Our Ref: 23/03197/HFUL
Your Ref: 41 Bog Gap Lane, Garage and E...

**South Cambridgeshire District Council
Application for Planning Permission**

Proposal: Demolition of the existing conservatory, single garage, and shed and replaced with a single storey side and link extension.

Site address: 41 Bogs Gap Lane Steeple Morden Cambridgeshire SG8 0PW

**LOCATION PLAN  
1:1250**

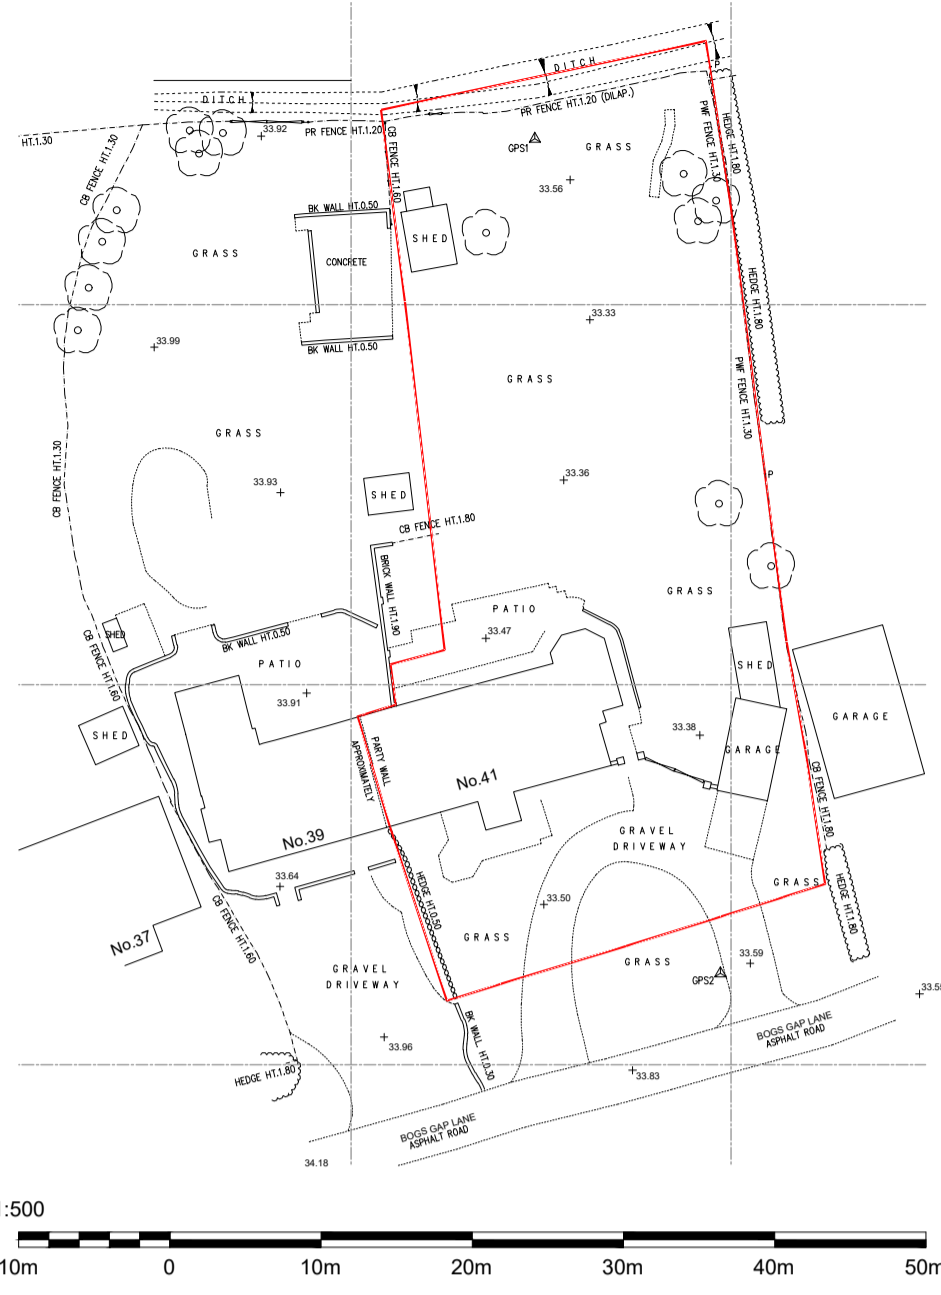
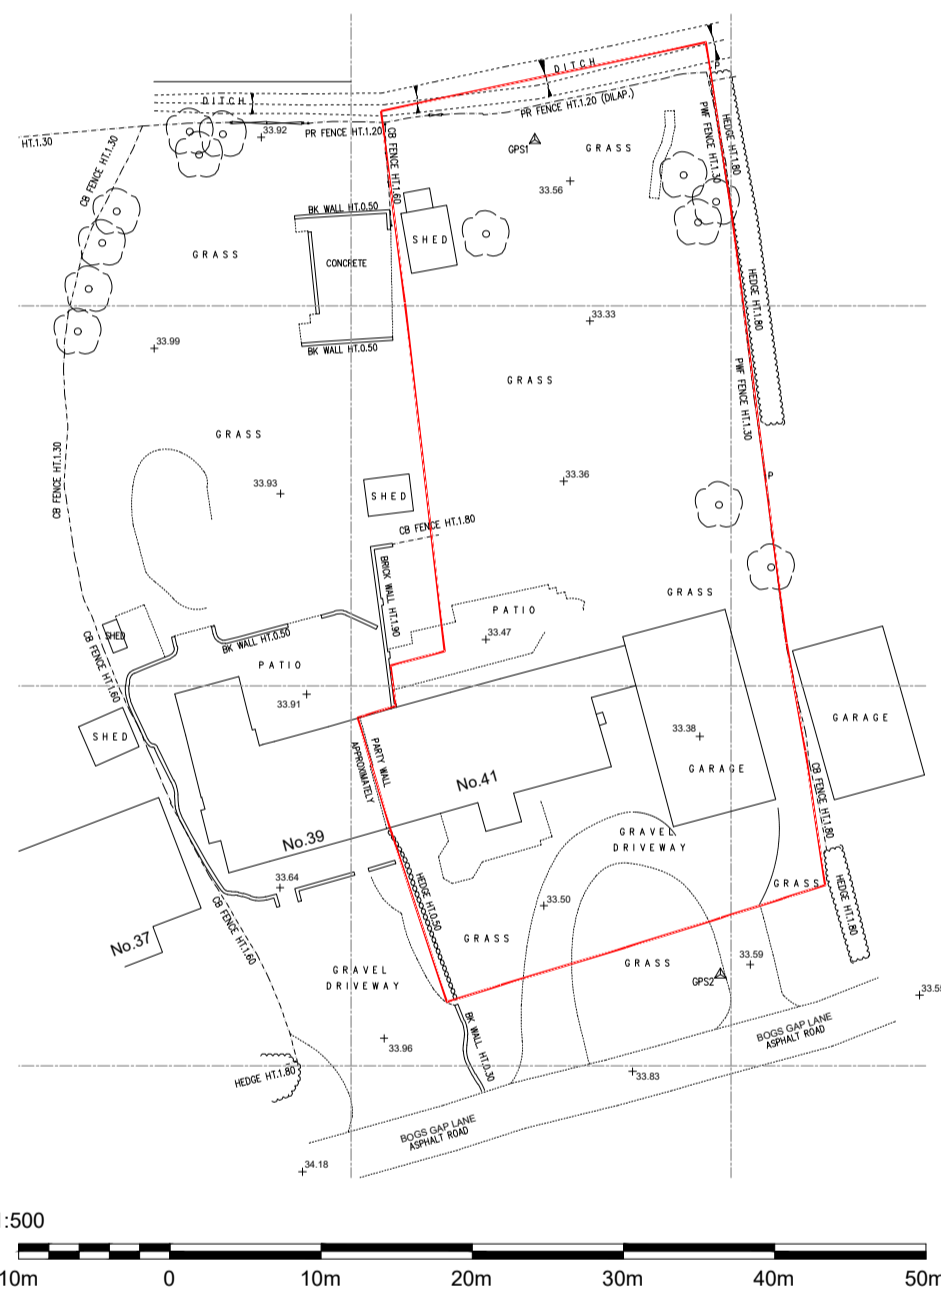
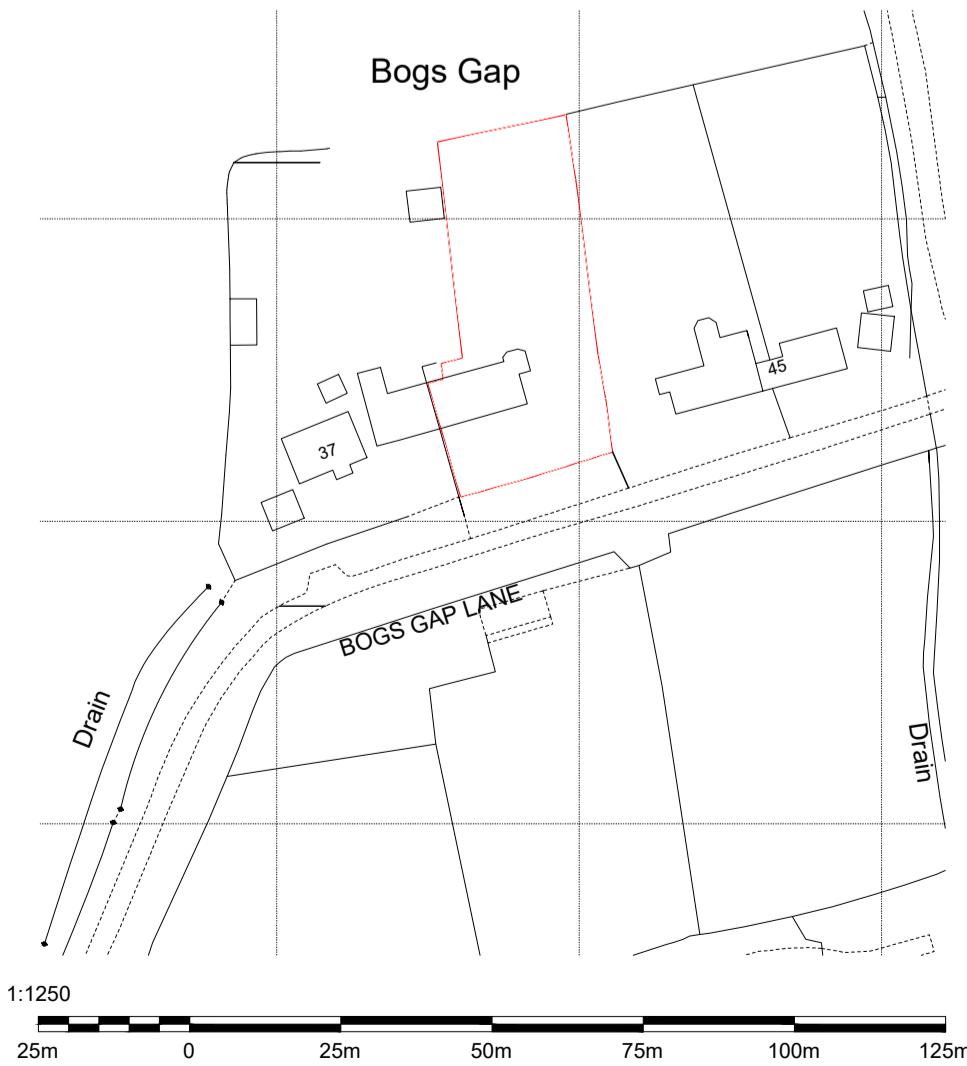
0. The location plan submitted has excluded from the red outline the main building, please provide an amended location plan which includes the whole site, namely the building itself and garden ground within the red outline.
